Your Ref: EP/159/17/DOC

Town & Country Planning Act 1990 (as amended)
Town and Country Planning (Development Management Procedure) (England) Order 2015
Application for approval of details imposed under planning permission EP/146/15/PL relating to
Condition 7 (Screen walls &/or fences) & Condition 9 (Flint Wall Panel)
Slaters Cottage 3 The Street, East Preston,

Arun District Council have decided to **REFUSE** details reserved by condition for the following reasons:

Drawing No. 217/536/6A

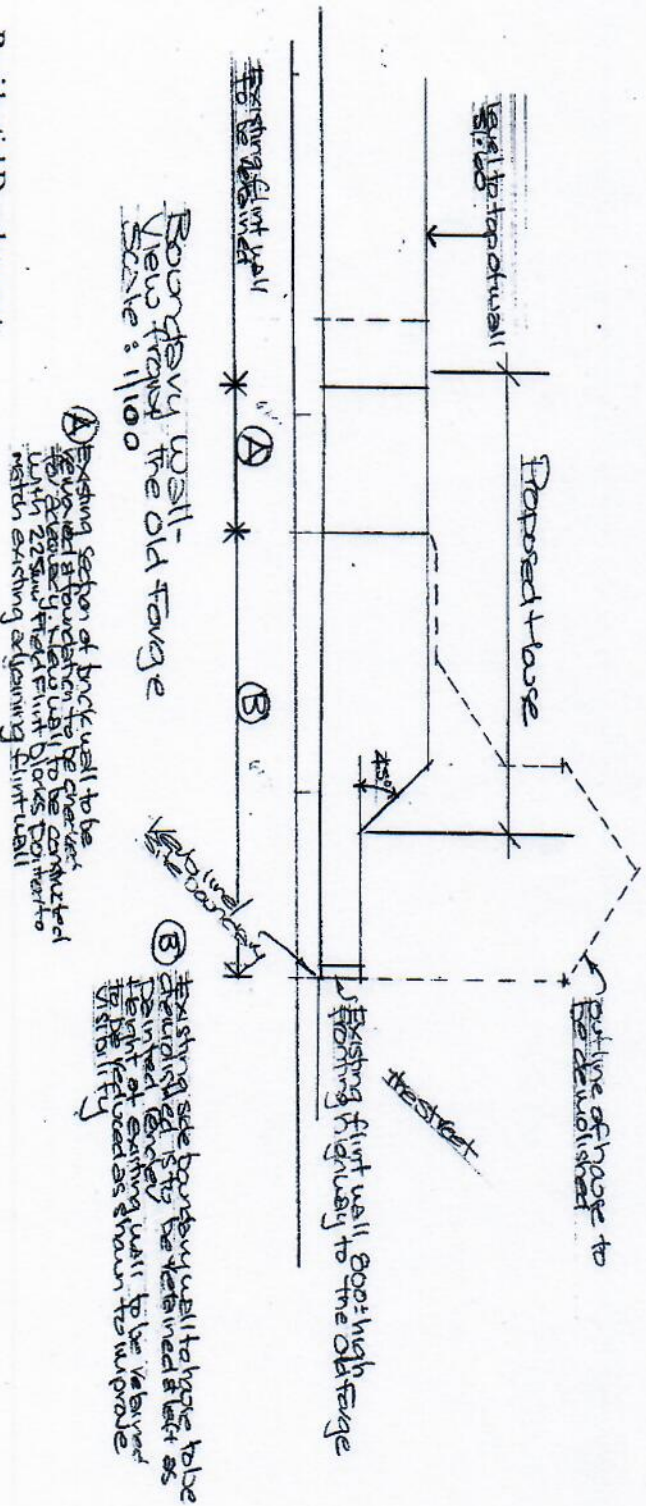
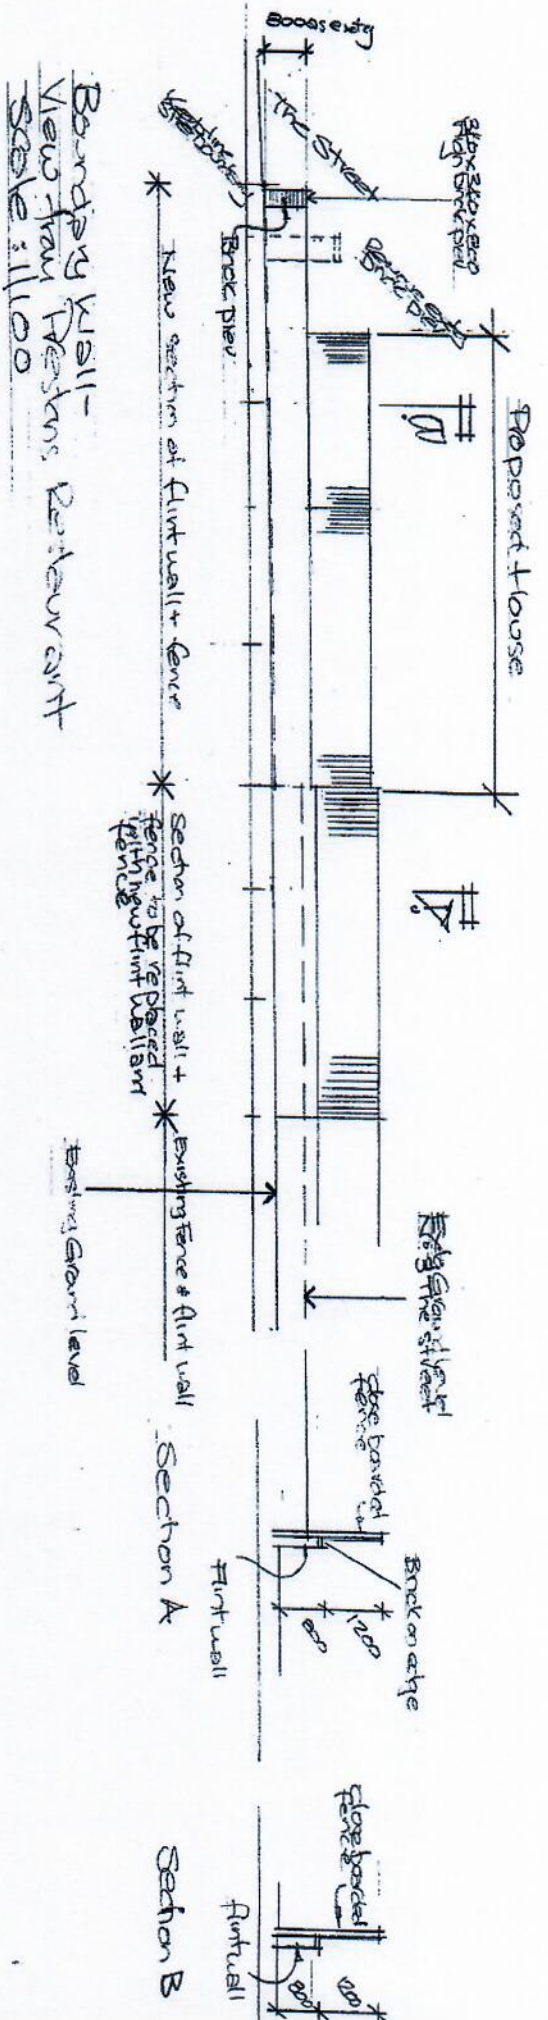
You are seeking amendment to approved drawing 217/536/6a which formed part of planning permission EP/146/16/PL with substitute drawing 6c. This cannot be considered as a Discharge of Condition application since it formed part of the approved plans. Further for your information, I would advise that the alteration proposed would not be supported. The approved flint wall should be provided.
